SUBJECT: Engineering Review Comment
Mountain View Electric Association Inc. (MVEA)

Project Name: McLean Minor Subdivision – Parcel #6128100014

Project Number: MS243

Description: Proposed development of 2 residential lots located at 2415 Hodgen Rd. and east of Roller Coaster Rd. in Township 11S, Range 66W, Section 28.

MCLEAN SUBDIVISION
BEING A PART OF THE NORTHEAST QUARTER OF SECTION 28,
TOWNSHIP 11 SOUTH, RANGE 66 WEST OF THE 6TH PRINCIPAL MERIDIAN,
COUNTY OF EL PASO, STATE OF COLORADO.

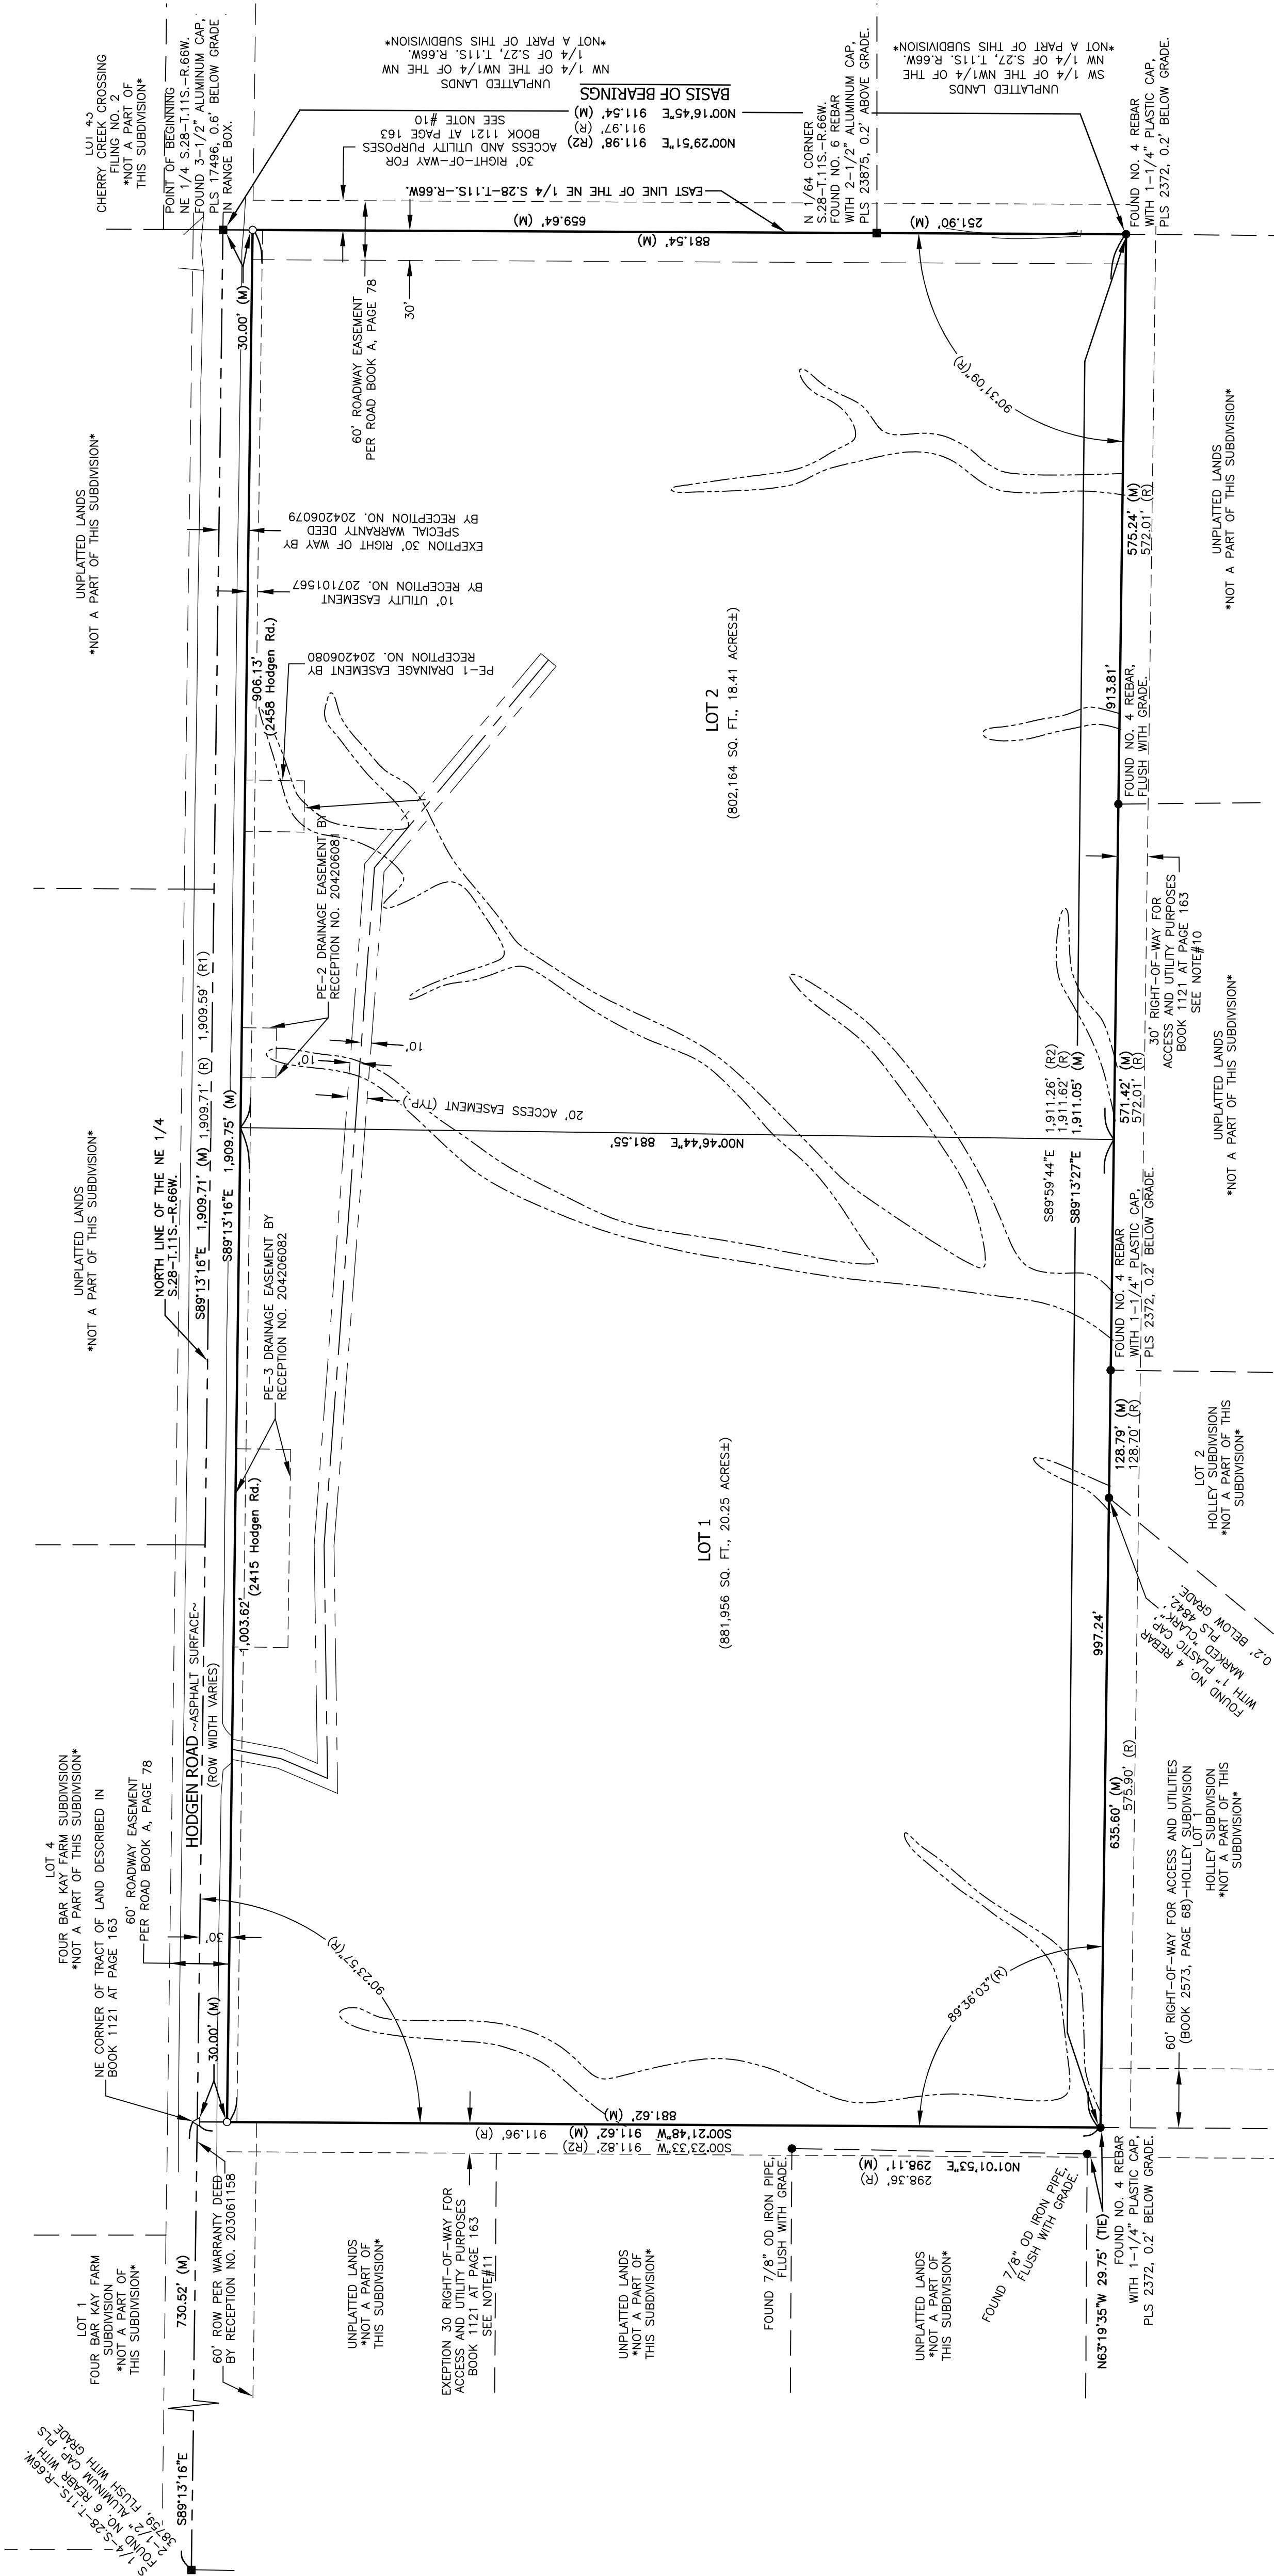
MVEA requests a ten (10) foot front, side, and rear lot utility easement and all tracts, along with a twenty (20) foot exterior utility easement on the plat. MVEA also requests the platting of MVEA's existing facilities with easements on the plat. Additional easements may be required.
